WEST SUSSEX COUNTY COUNCIL CONSULTATION

TO:	Arun District Council FAO: Simon Davis
FROM:	WSCC - Highways Authority
DATE:	1 February 2021
LOCATION:	Land at Bilsham Road
SUBJECT:	Y/155/20/DOC Approval of details reserved by condition imposed under ref Y/91/17/OUT relating to Condition Nos 7 - landscaping & layout, 8 - Arboricultural Method Statement & Tree Protection Plan, 10 - surface water drainage, 13 - Ecological Management & Mitigation Plan, 15 - external lighting and 21 - Travel Plan.
DATE OF SITE VISIT:	n/a
RECOMMENDATION:	No Objection
S106 CONTRIBUTION TOTAL:	n/a

Planning application Y/155/20/DOC seeks discharge of conditions 7 Landscaping & layout, 8 Arboricultural Method, 10 surface water drainage, 13 ecological management & mitigation plan, 15 external lighting and 21 travel plan.

BILSHAM ROAD, YAPTON			
Drawing Title: PRELIMINARY ENGINEERING LAYOUT. SHEET 2 OF 2			
Client: BILSHAM ROAD DEVELOPMENT LLP			
Scale: 1:500 @A0	Date: FEB 20	Designed: NA	
Drawn: LS	Checked: JH	Approved: GG	
Job No: 19-326	Drawing No: 19-326/010	Rev: J

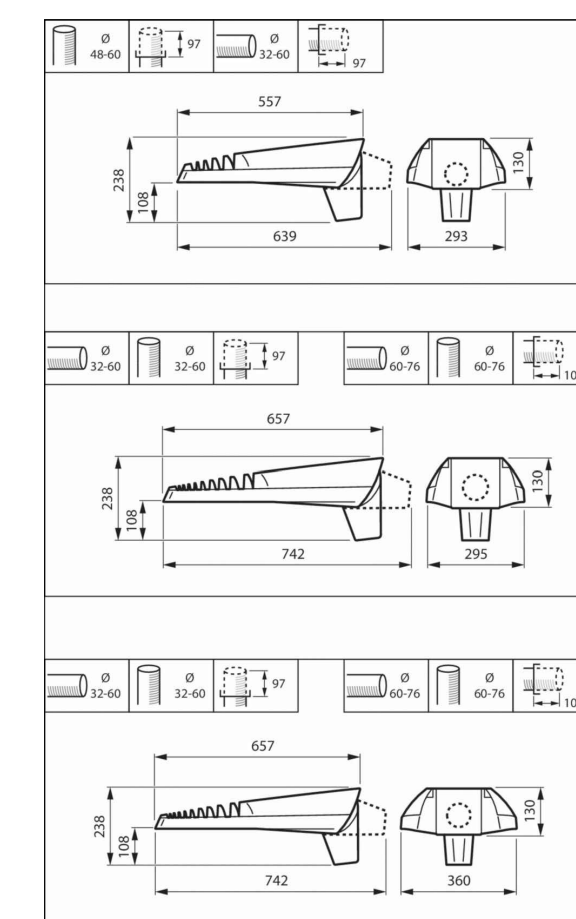
The applicant has submitted a lighting specification and detailed on a plan where they propose lighting columns to be located. If the roads are intended to be adopted the street lighting shall have to be in accordance with WSCC PFI Street Lighting Contract.

WSCC Street Lighting Engineer has confirmed that the proposed design accords with the requirements of the PFI contract.

Therefore WSCC as Highway Authority has no objections to the discharge of this condition. Should the street lighting design change then WSCC should be reconsulted.
